SUBJECT: Engineering Review Comment
Mountain View Electric Association Inc. (MVEA)

Project Name: Ivilo Heights Subdivision

Project Number: SF245

Description: Proposed development of 2 residential lots on approximately 6 acres located at 6225 Vessey Rd. in Township 12S, Range 65W, Section 06.

Final Plat
VILO HEIGHTS SUBDIVISION

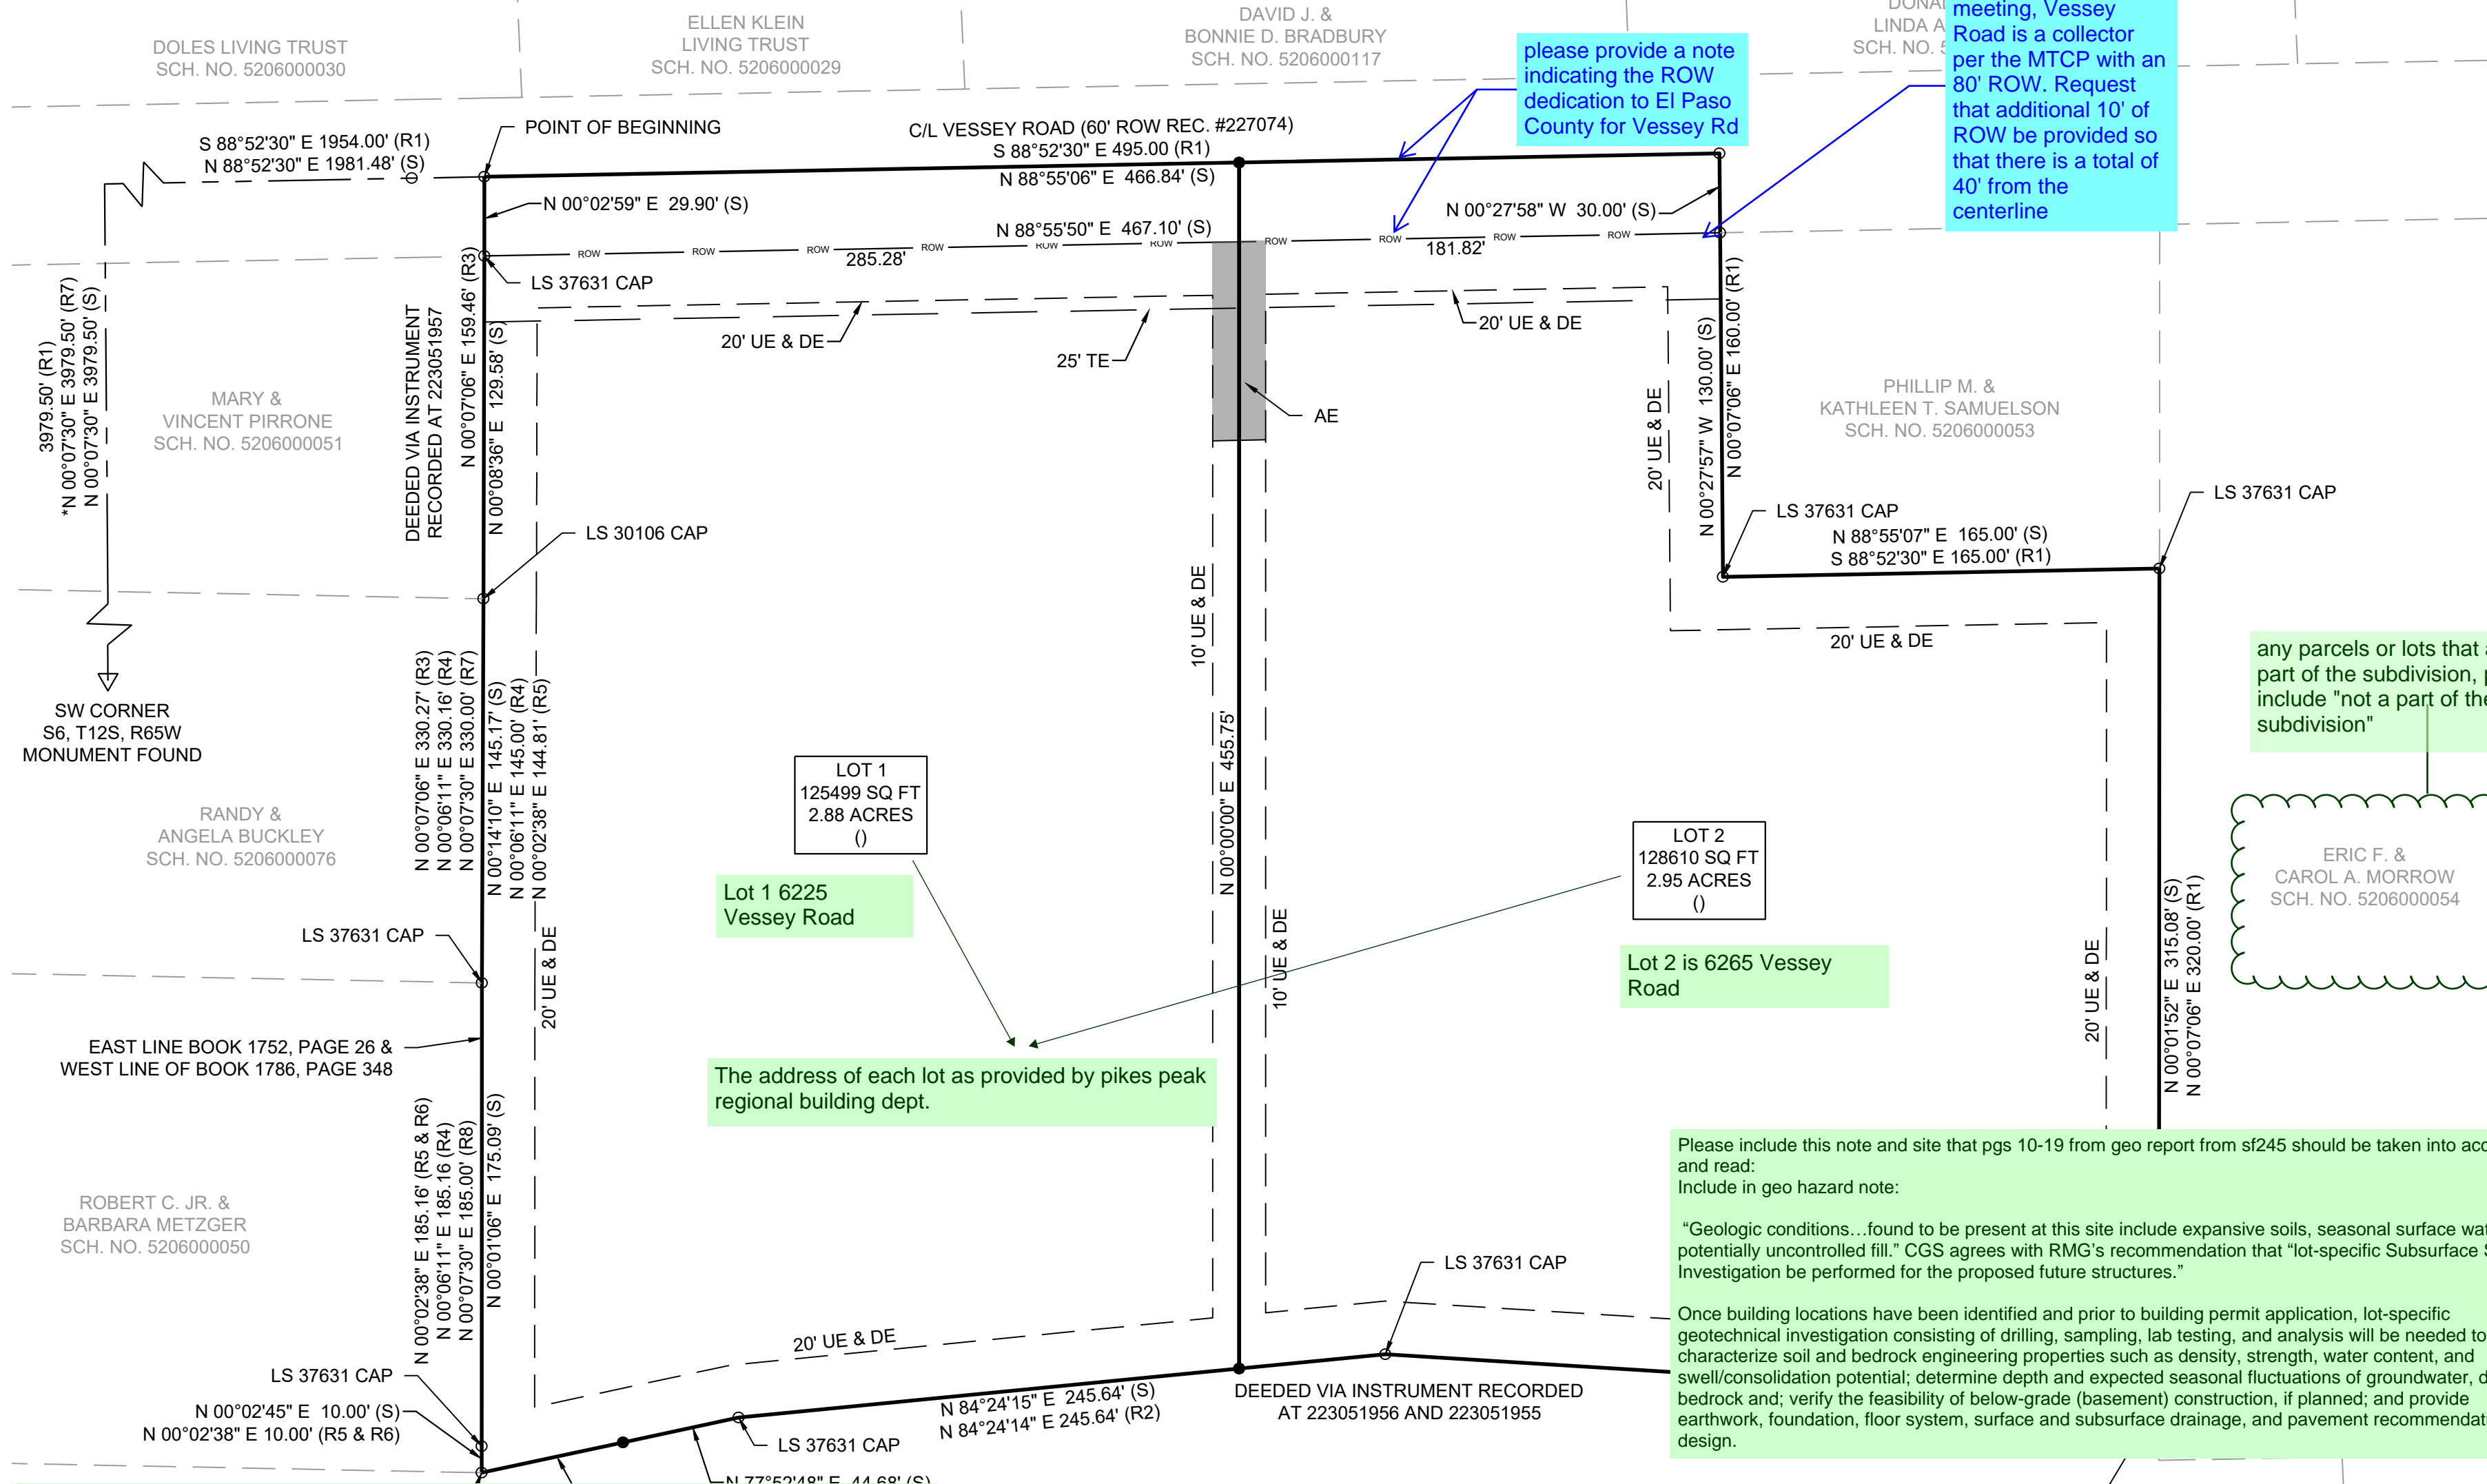
MVEA requests a ten (10) foot front, side, and rear lot utility easements and all tracts, along with a twenty (20) foot exterior utility easement on the plat. MVEA also requests the platting of MVEA's existing facilities with easements on the plat. Additional easements may be required.
